**SECTION 96a APPLICATION TO PLANNING PERMISSION REF: CHE/22/00540/FUL
CHESTERFIELD ROYAL HOSPITAL, CHESTERFIELD ROAD, CALOW, CHESTERFIELD,
DERBYSHIRE, S44 5BL**

On behalf of Derbyshire Healthcare NHS Foundation Trust, please find enclosed a Non-Material Amendment (NMA) application to regularise subtle design changes to permission ref: CHE/22/00540/FUL.

This application seeks to regularise subtle amendments to the layout of the above approved development, by amending condition 2 (list of approved plans / documents) of permission ref: CHE/22/00540/FUL. This approach was agreed by Ms. Helen Frith prior to the submission.

Subsidiary
Construction Approval
Project
Derbyshire Healthcare NHS Foundation Trust
New Mental Health Accommodation - Chesterfield (Landscape)
Chesterfield Hospital, Derbyshire North
Drawing
Planting Plan Overview

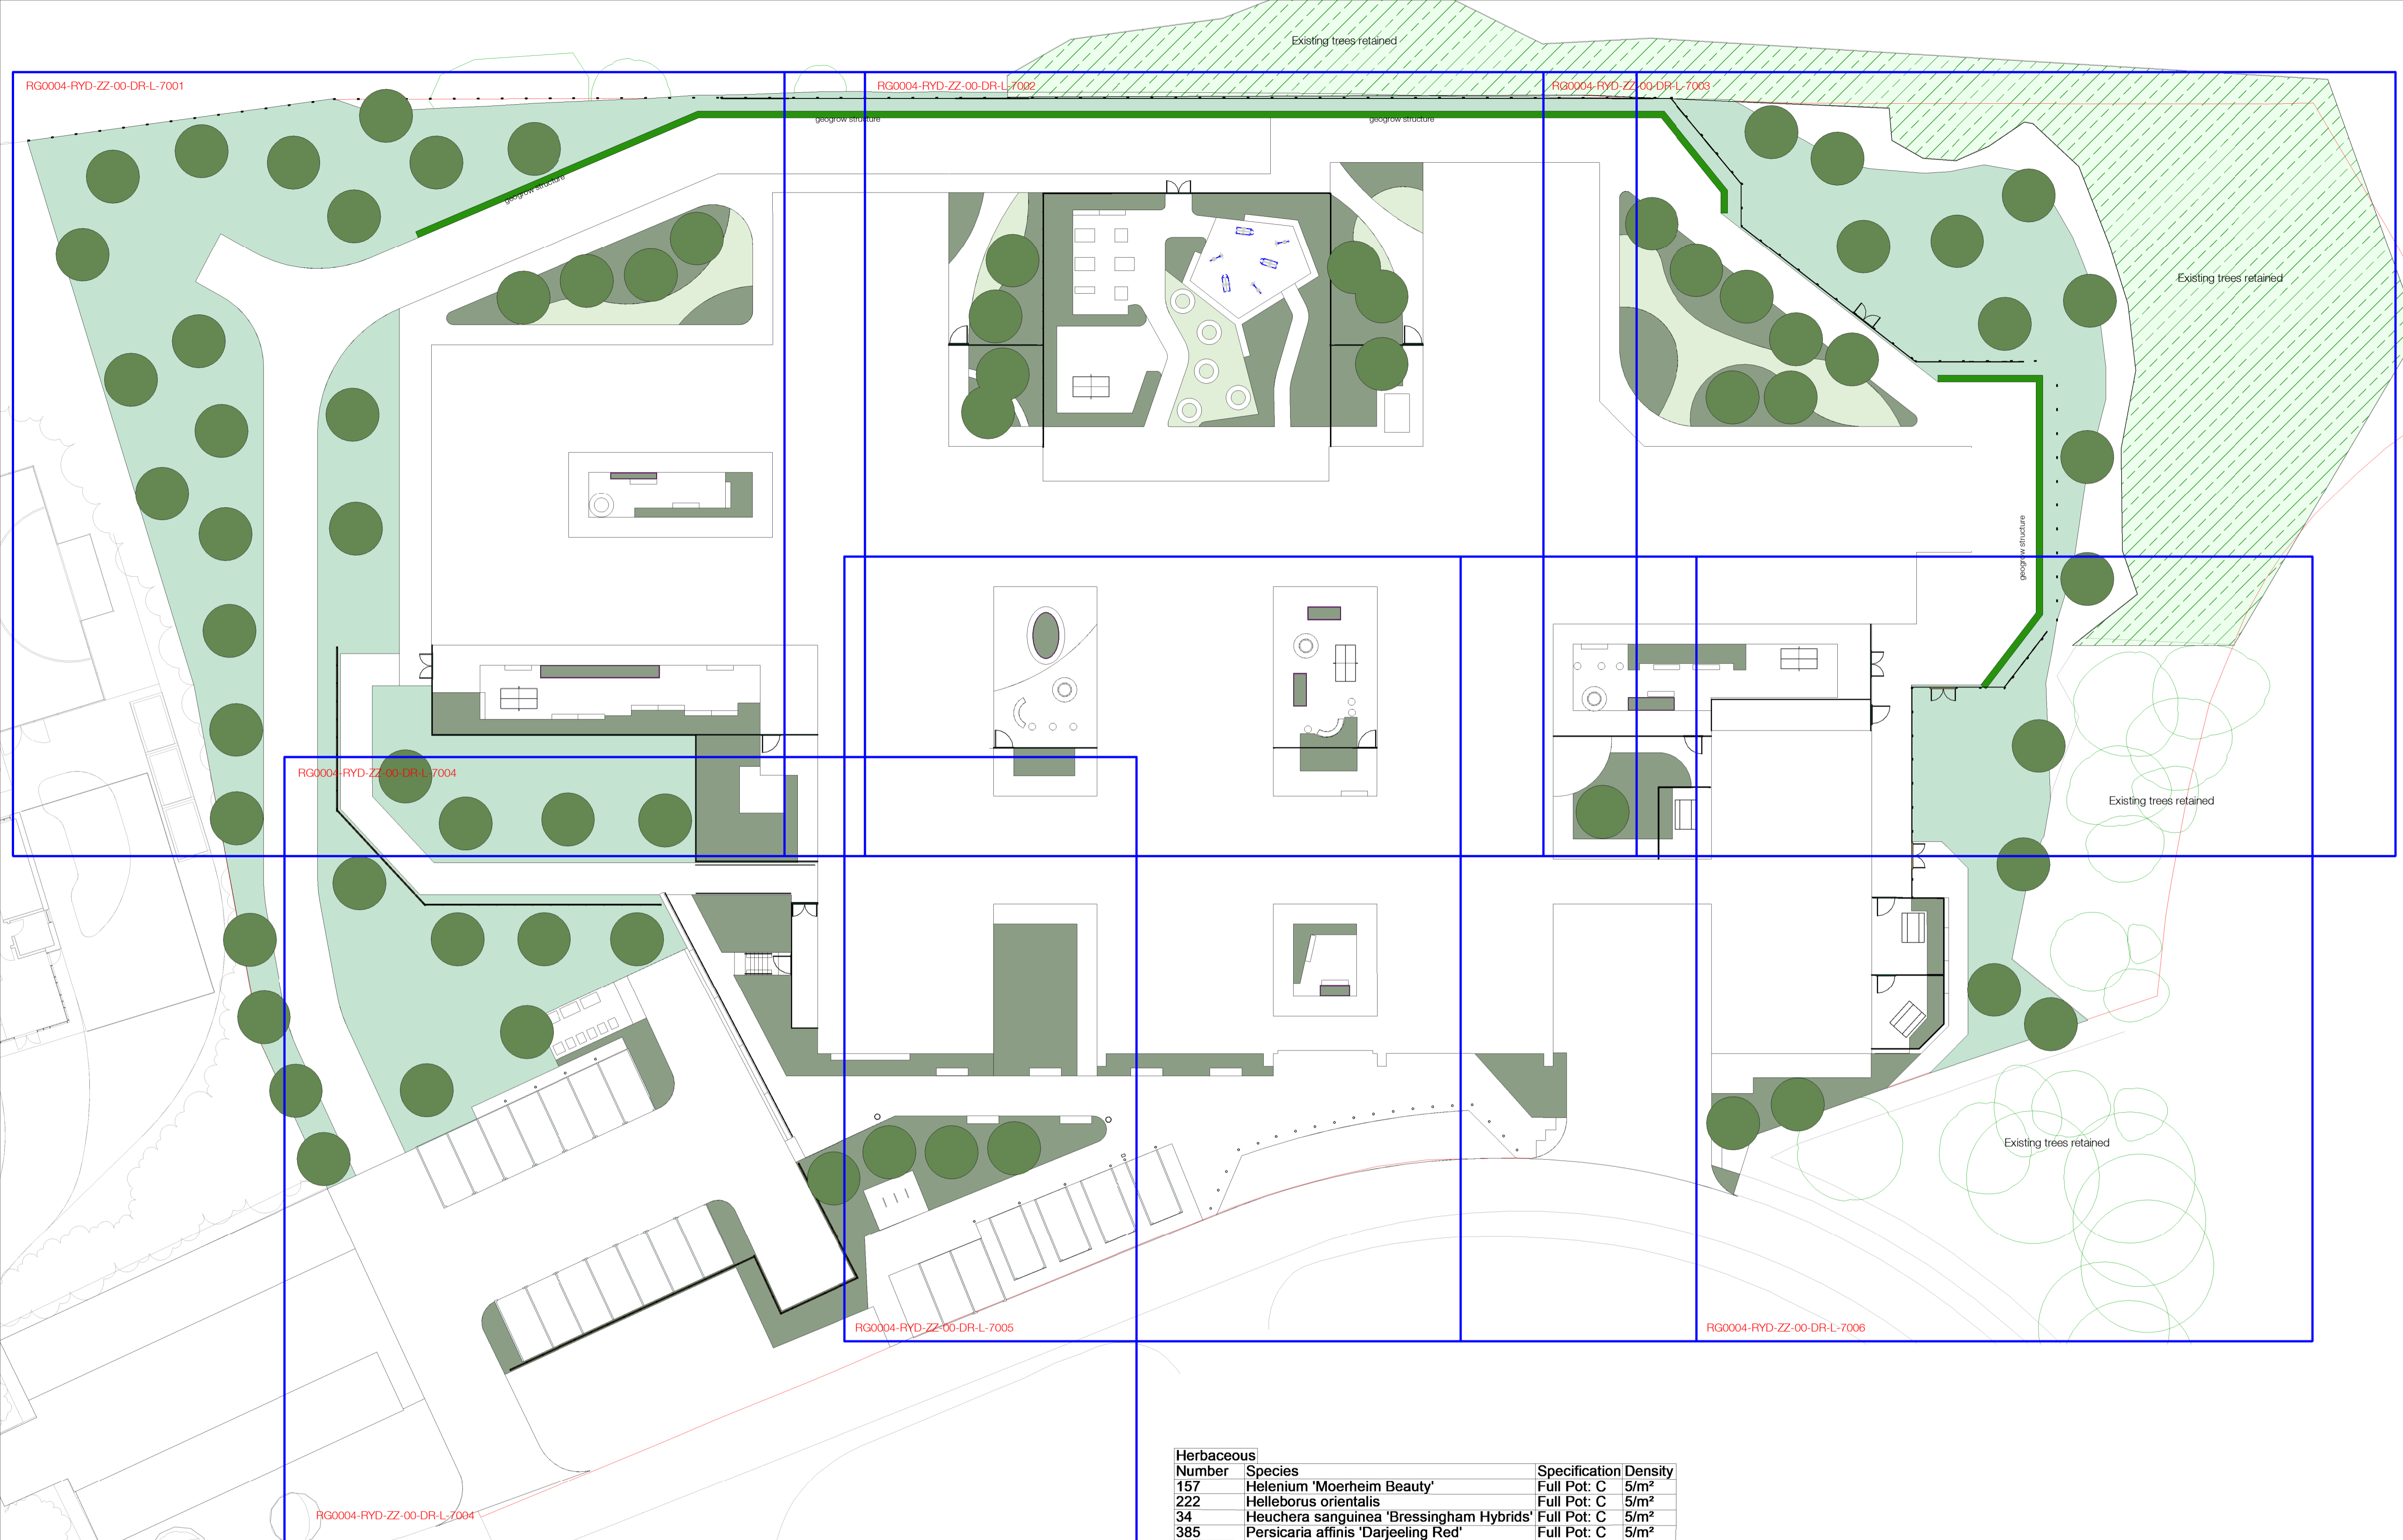
- Retaining wall structure to change to a vegetated retaining wall.
- Removal of fences and gates at the police/ambulance vehicular entrance.
- Addition of stairs to hard landscaping proposals.
